Ref: 26.118r01v04

**RE: 2 & 2A BULLECOURT AVENUE, MILPERRA
STATE SIGNIFICANT DEVELOPMENT 97092958
INDEPENDENT RISK ASSESSMENT**

The subject intersection, as originally proposed in the SSDA, is shown in **Figure 1**. An amended design in response to Agency comments, is provided in **Figure 2**. Larger scaled drawings are provided in **Attachment 1** and **Attachment 2** for reference.

Attachment 1

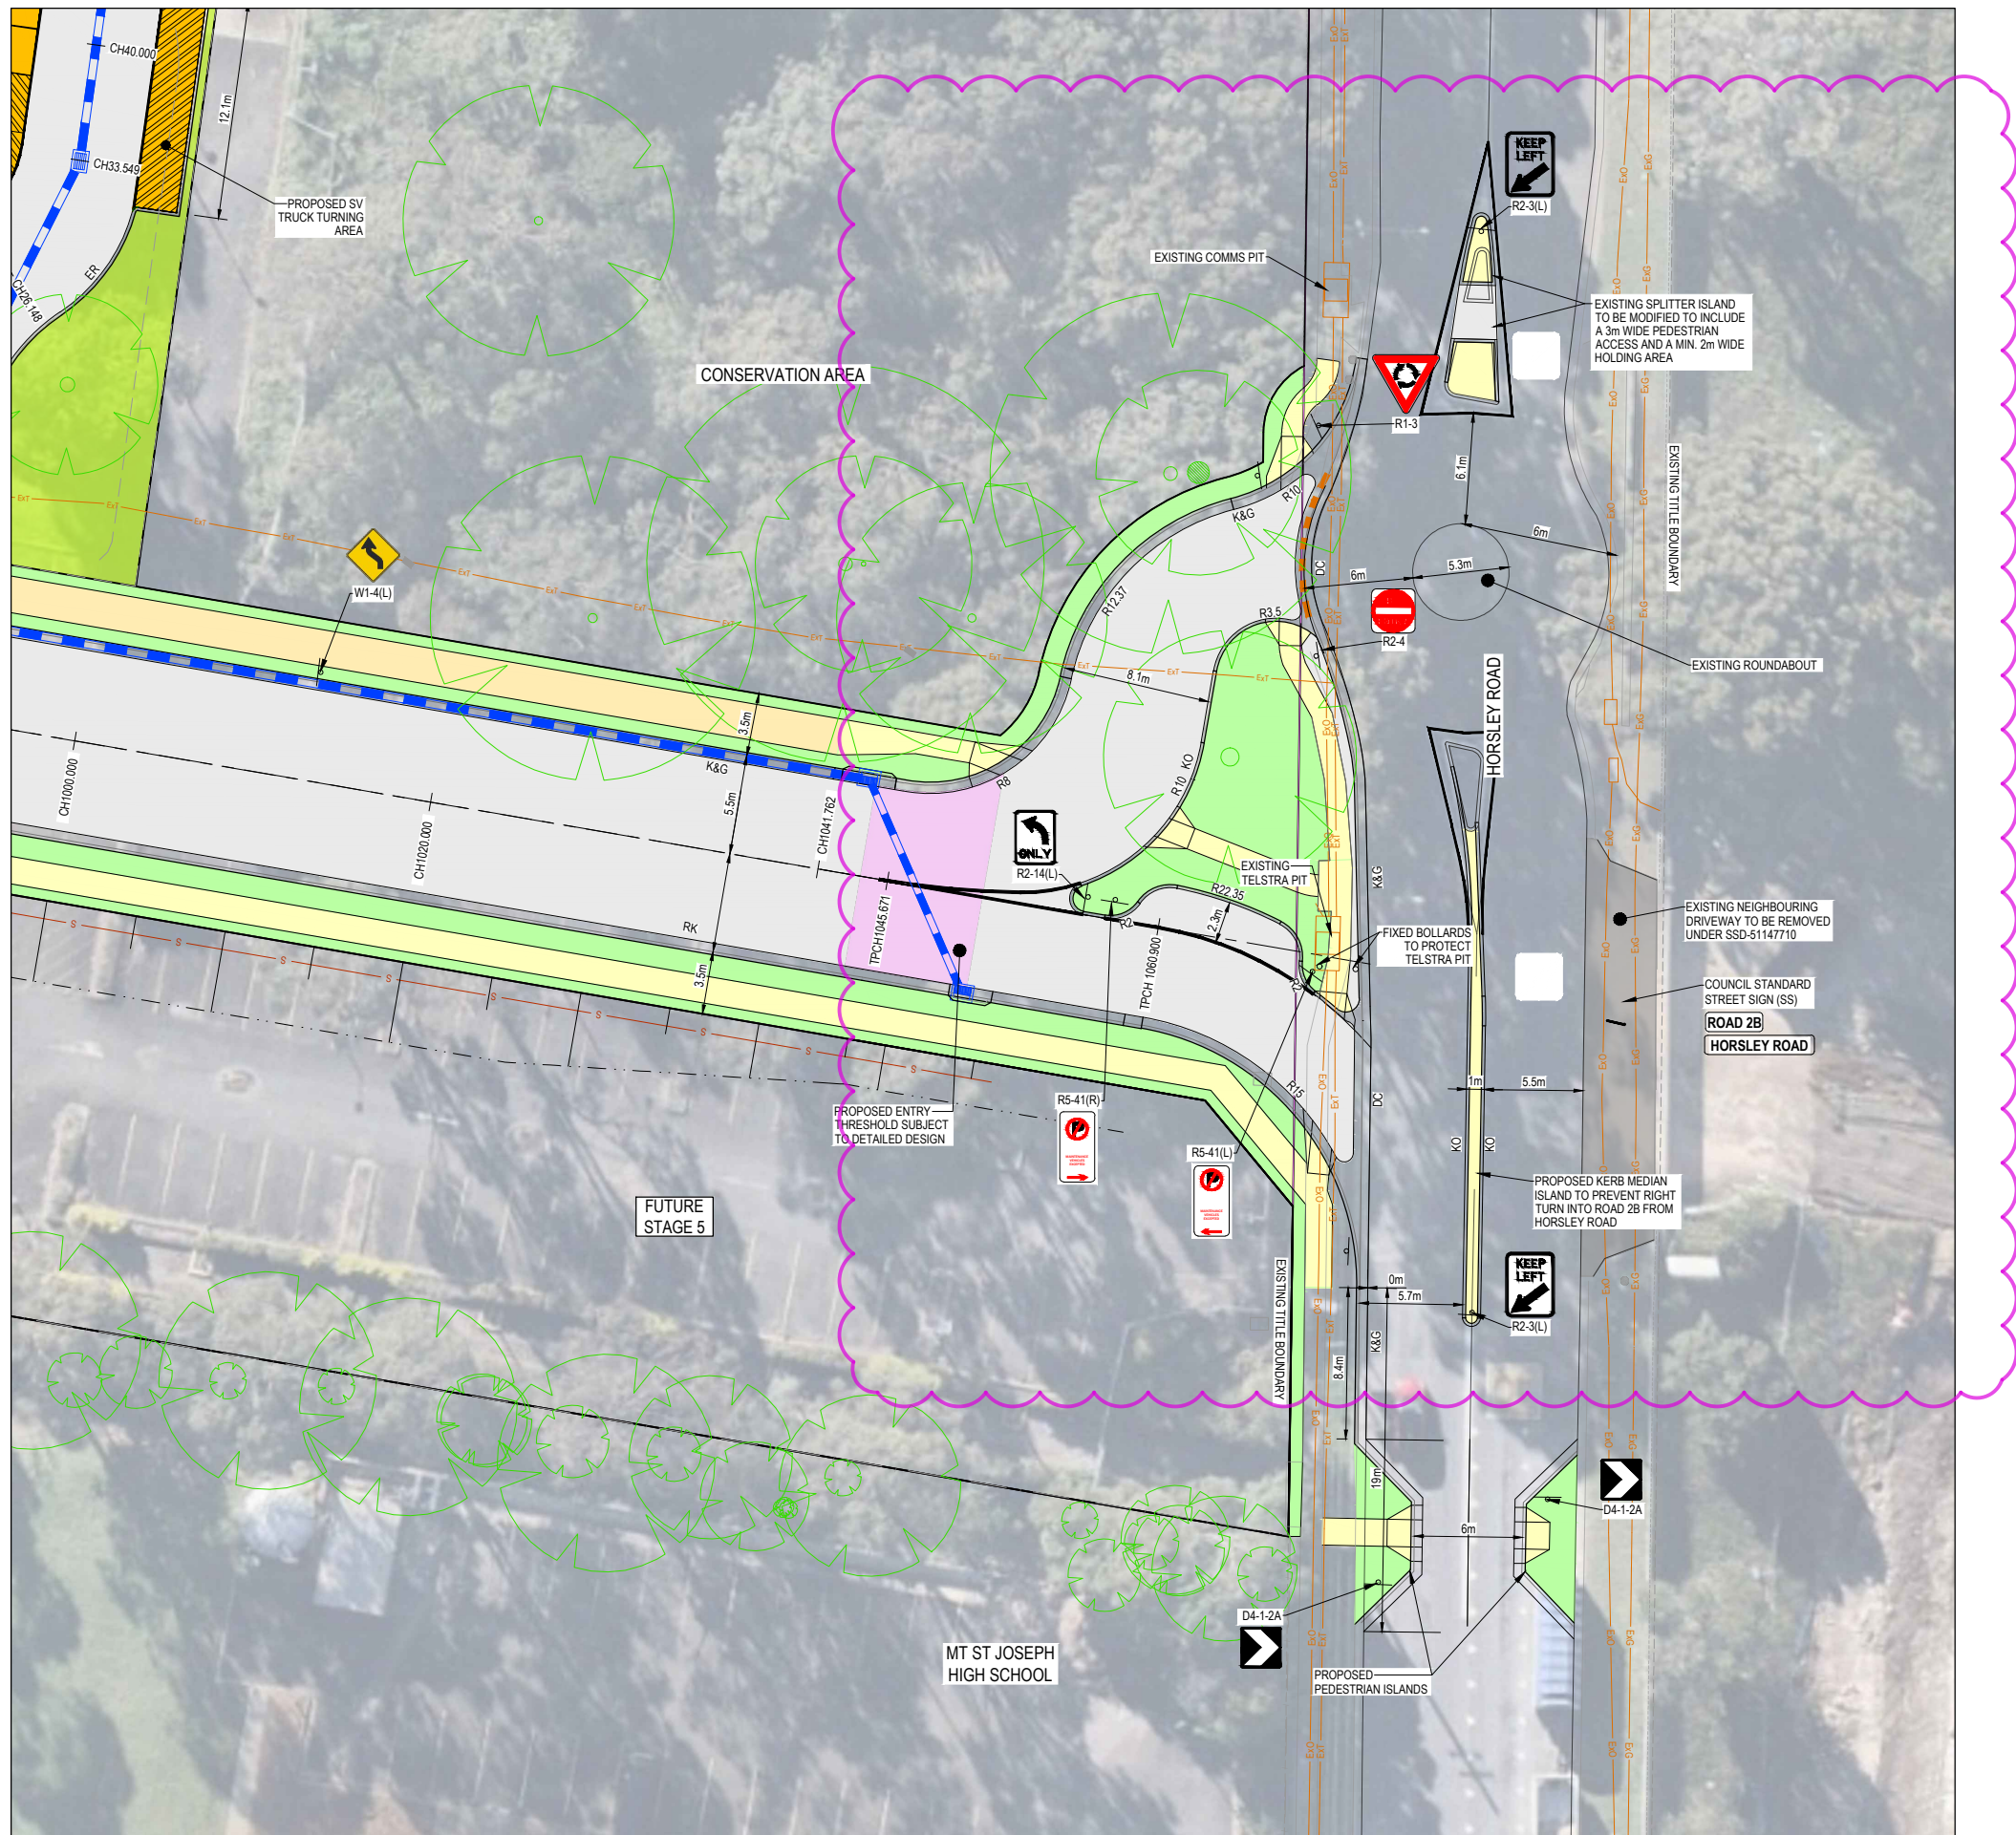
ITEM	LOCATION	ROAD SAFETY FINDING	LIKELIHOOD	SEVERITY	LEVEL OF RISK
1	Left turn entry	The design of the left turn entry lane from Horsley Road appears to enable a relatively high entry speed when entering Road 2B. The higher speed upon entry has potential to increase the severity of a crash in this location. There are a number of potential crashes in this location, including: - Rear-end or side-swipe crashes with vehicles in what appear to be an indented parking bay for vehicles. - The pedestrian movements at the pram ramp between the southern kerb of Road 2B and the central island area between the entry and exit lanes on Road 2B. 	Unlikely	Minor	Low
2	Vehicle queuing	The location of the pram ramp on Road 2B, approaching the roundabout, is located in close proximity to the roundabout. In the event of vehicle queuing, a pedestrian will need to walk within Road 2B to go around the queued vehicle and may even step within Horsley Road to pass the queued vehicle. There is a risk of vehicle to pedestrian crashes based on the pedestrian movements in this location, and the need for the pedestrian to walk within the roadway around vehicles. It is noted that under existing conditions, the western approach to the roundabout is a driveway where vehicles are legally required to give-way to pedestrians.	Rare	Moderate	Low

ITEM	LOCATION	ROAD SAFETY FINDING	LIKELIHOOD	SEVERITY	LEVEL OF RISK
		- There is reduced sight lines to queuing at the Road 2B approach to the roundabout. There is a risk of rear-end crashes.

Attachment 2

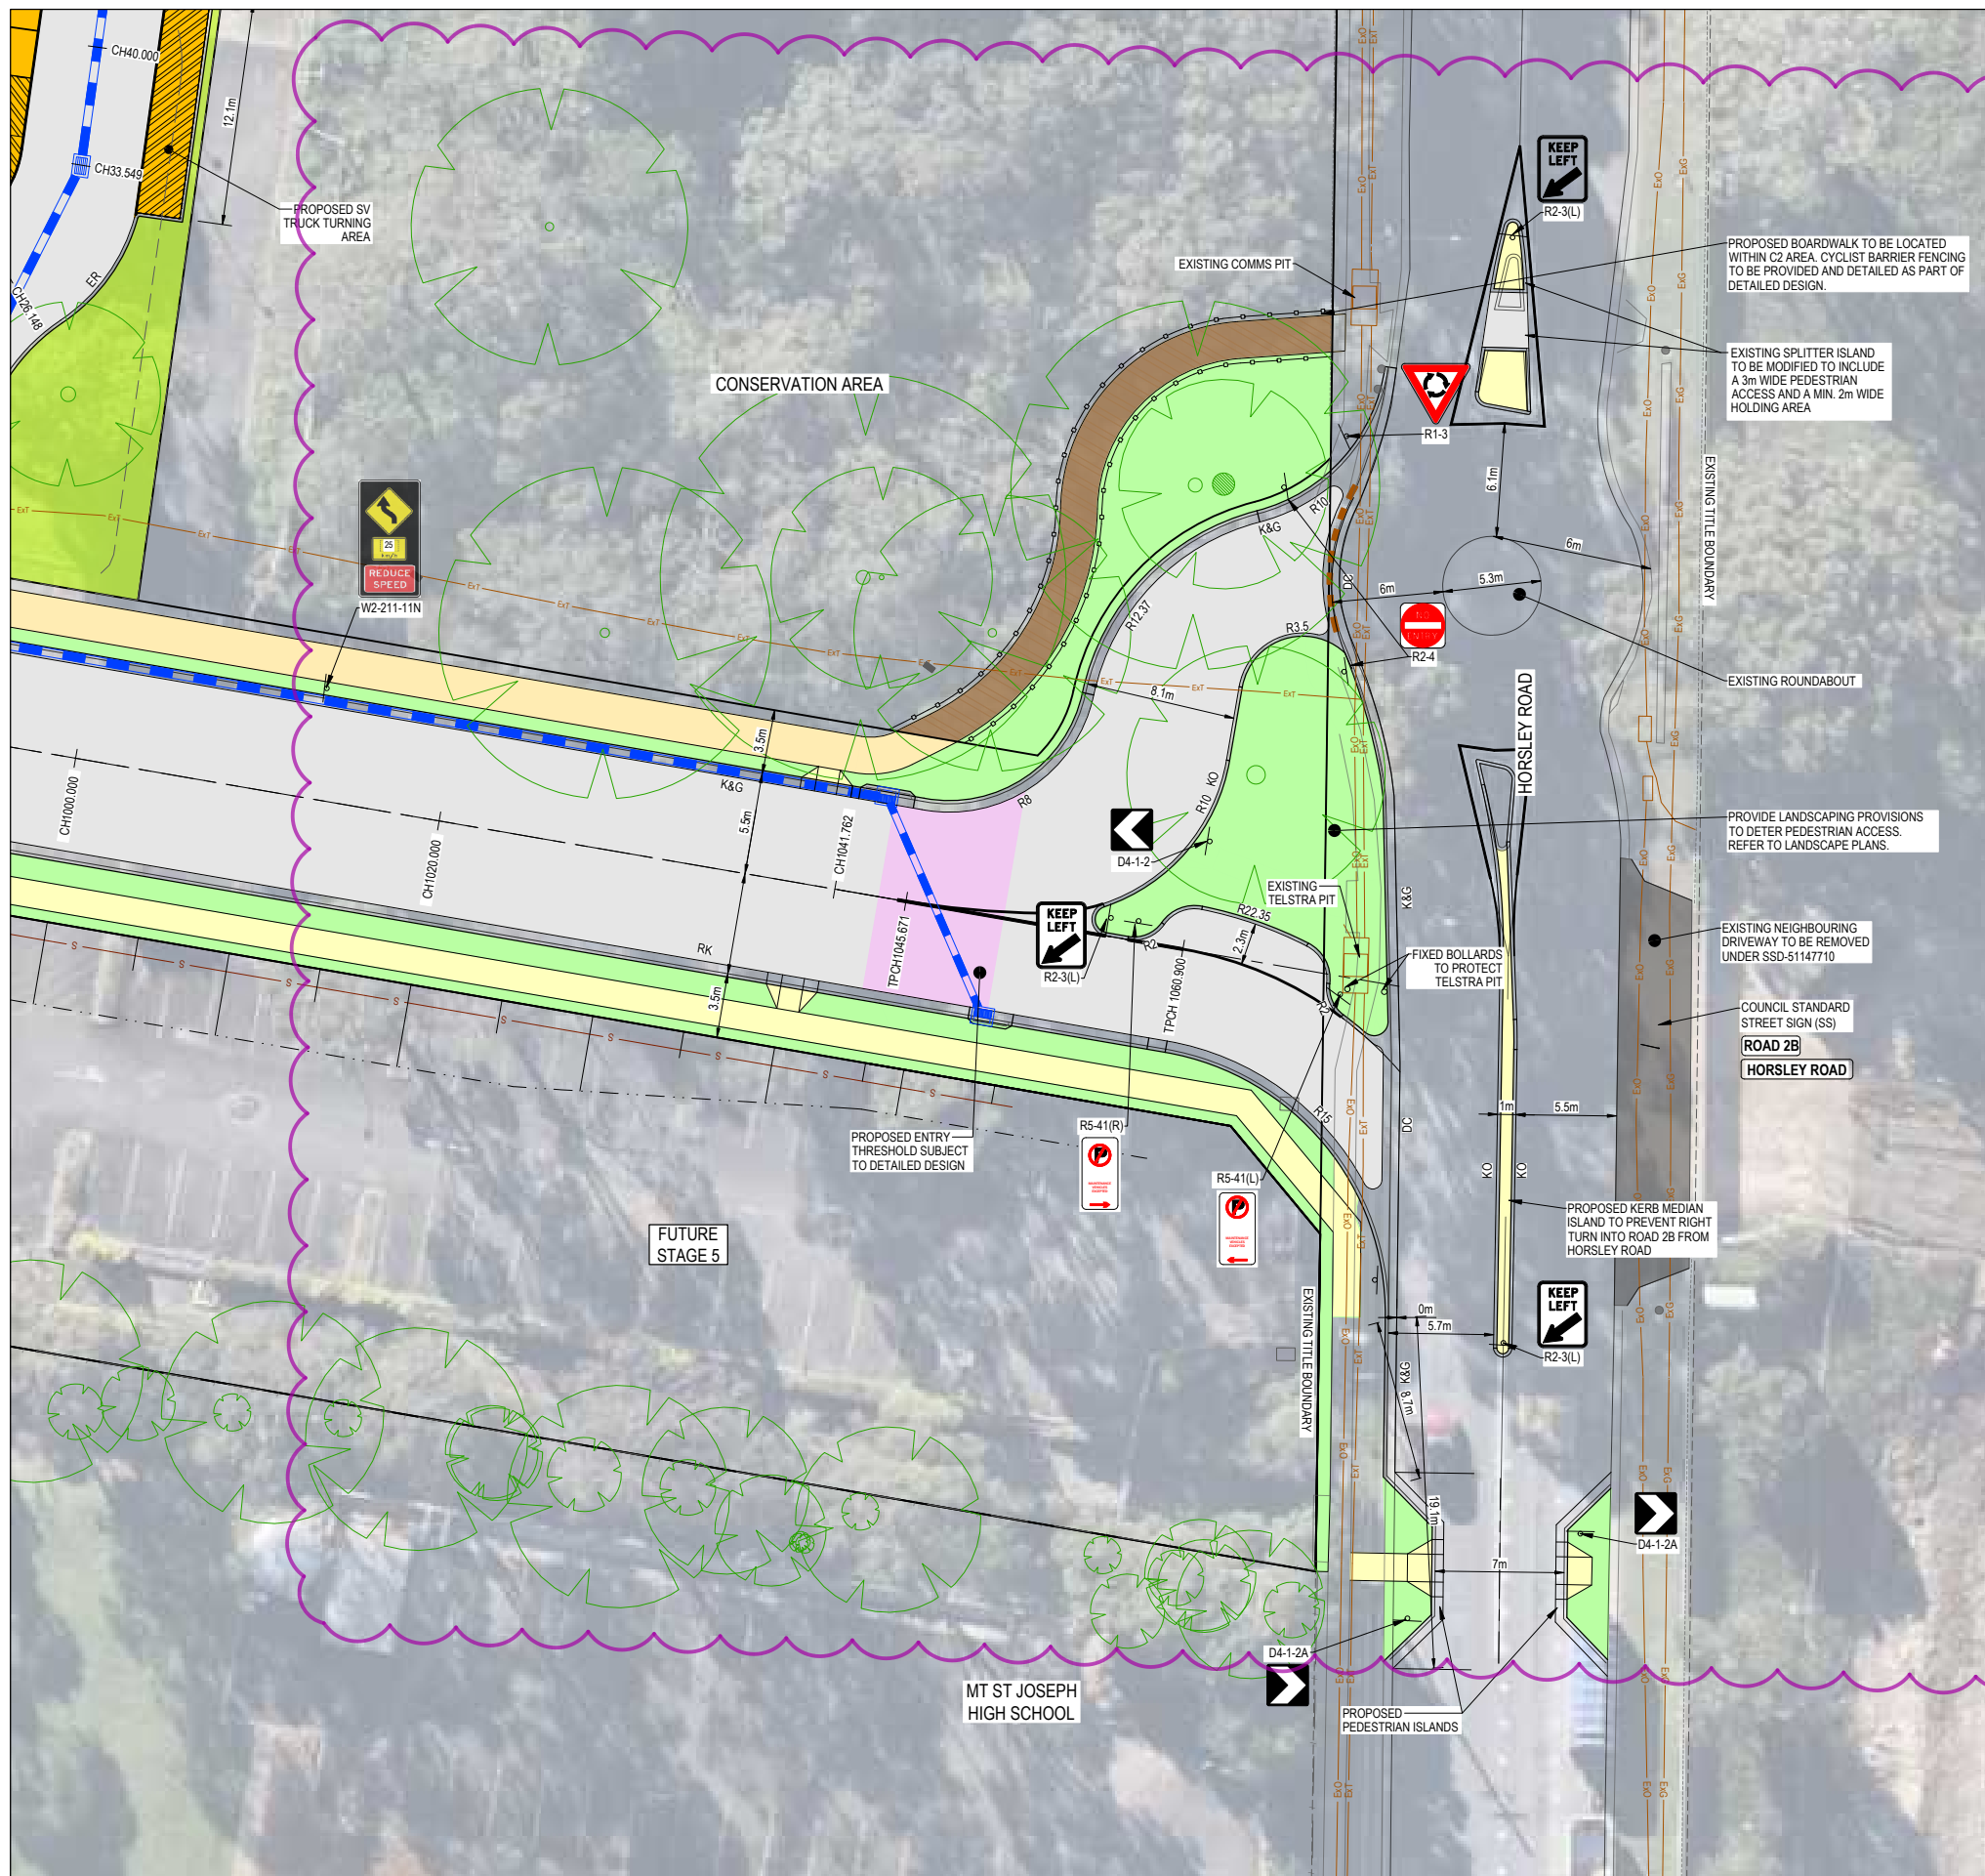
ITEM	LOCATION	ROAD SAFETY FINDING	LIKELIHOOD	SEVERITY	LEVEL OF RISK
1	Left turn entry	The design of the left turn entry lane from Horsley Road appears to enable a relatively higher entry speed when entering Road 2B. The higher speed upon entry has potential to increase the severity of a crash in this location particularly rear-end or side-swipe crashes with vehicles in what appear to be an indented parking bay for vehicles. 	Unlikely	Minor	Low
2	Vehicle Queuing	The risk item identified under Design 1 has been addressed in Design 2, removing the conflict point and removes or reduces this risk.			
3	Footpath Intersection	The risk item identified under Design 1 has been addressed in Design 2, removing the conflict point and removes or reduces this risk.			
4	Share path design	The risk item identified under Design 1 has been addressed in Design 2, removing the conflict point and removes or reduces this risk.

5	Road 2B approach speeds	The risk item identified under Design 1 has been addressed in Design 2, with improved signage and messaging to the motorist. This removes or reduces this risk.			
6	Footpath Fencing	It is unclear what fencing treatment is proposed for the shared path through the conservation area. There is a risk of cyclist snagging on the fencing, or toppling over the fence when traversing through the conservation area <i>It is understood that the boardwalk design through the conservation area will be further developed as part of detailed design and include bicycle compliant fencing, significantly reducing the potential for snagging and falls.</i>	Unlikely	Minor	Low

The focus of this Independent Risk Assessment is changes to the intersection and the introduction of Road 2B. The notable difference between Design 1 (**Figure 1**) and Design 2 (**Figure 2**) is the pedestrian footpath design and alignment. Design 2 routes the footpath away from the Horsley Road frontage.

Whilst Design 1 and Design 2 share some common risk findings, the design changes that result in Design 2, removes risk items 2, 3, 4, and 5 identified in **Table 2** with residual risks being low. Design 2 provides an improved outcome for pedestrians, by minimising the number of conflict points when walking north – south on Horsley Road.
